Town & Country Planning Act 1990 (as amended)
Town and Country Planning (Development Management Procedure) (England) Order 2015

Variation of condition 5 imposed under FG/1/18/HH to have first 2 No. west facing velux windows to be clear glass & fully opening & to have the remaining velux windows (2 No. west & 2 No. east) to be obscured by a 'film' up to height of 1.7m, fixed shut with internal lock or bolt fasteners & be able to open these 4 No. velux windows 4 times per year to be cleaned & maintained.

63 Midhurst Drive Ferring

PROPOSED ELEVATIONS

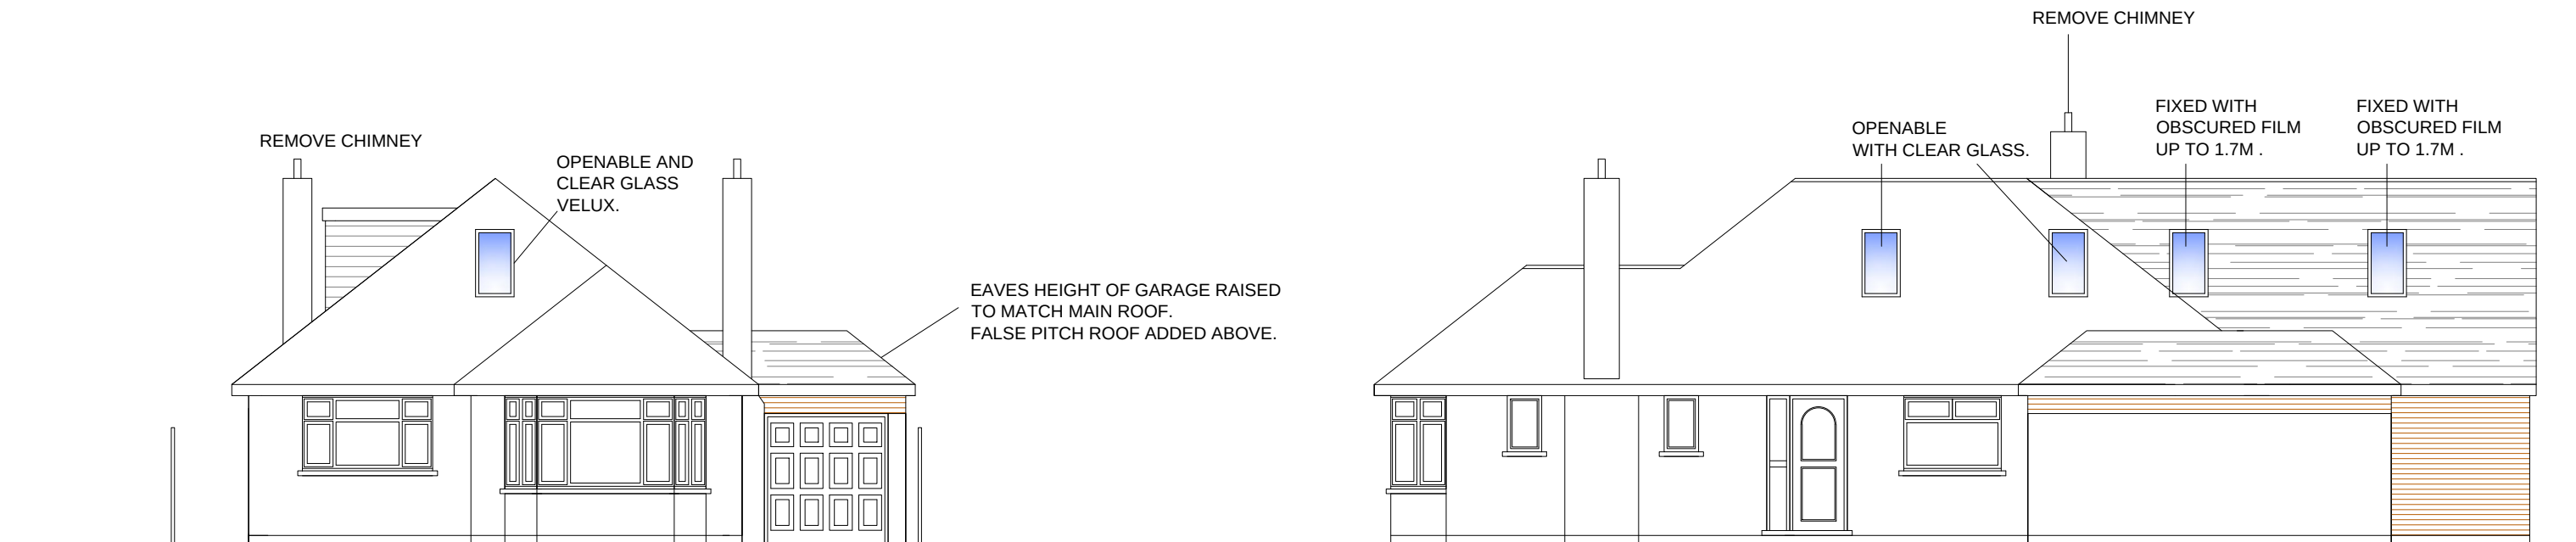
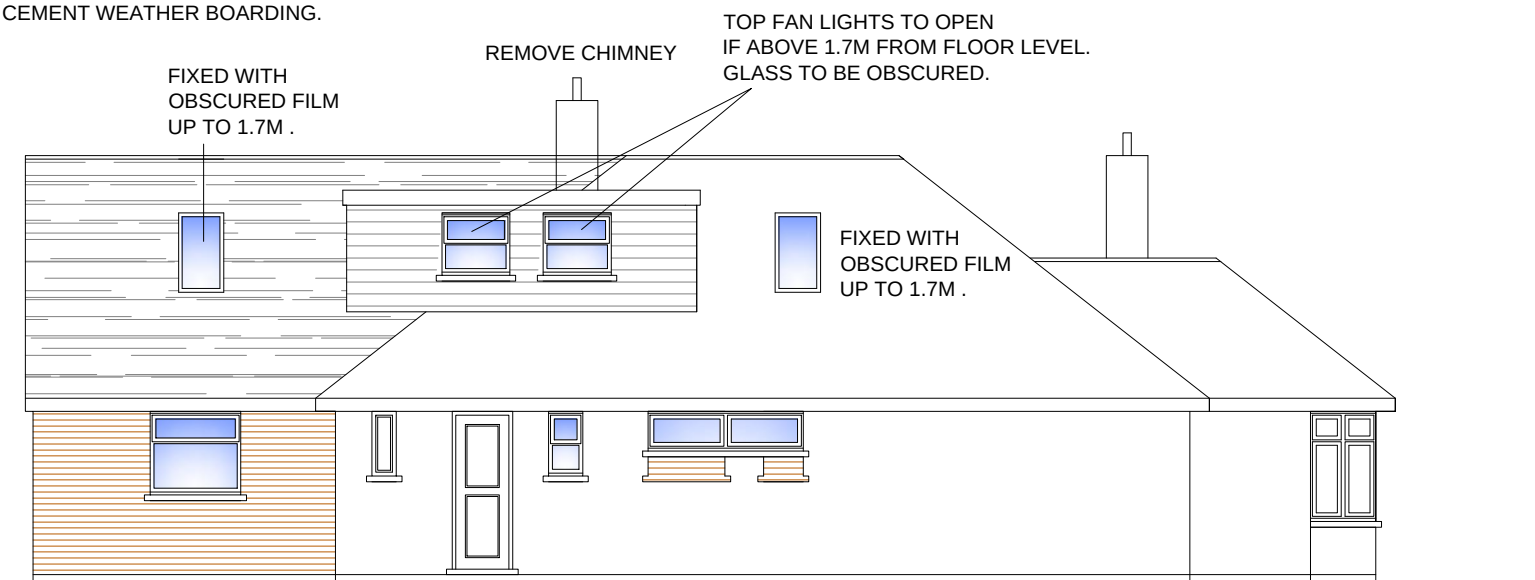
I am lodging an objection to the proposed changes to the original planning application concerning changing the velux window units from closed to opening units, obscured to filmed glass & clear glass.

I have noticed that all the windows on the sides of the extension at 63 Midhurst Drive have been installed with opening window units, including the top dormer windows, contrary to the original and specific terms of the planning permission.

As to the issue of putting film on the glass instead of having frosted glass installed, as was a stated requirement of the original planning permission. I would ask why the owners disregarded the original judgement and installed all the windows with clear glass ? The two lower clear glass dormer windows have had a film added which could easily be removed at a later date. This would remove the protection of the neighbours privacy. Is this now deemed an unnecessary requirement? I thought all extensions of this type, overlooking a neighbours garden, required permanent obscured glass not removable film.
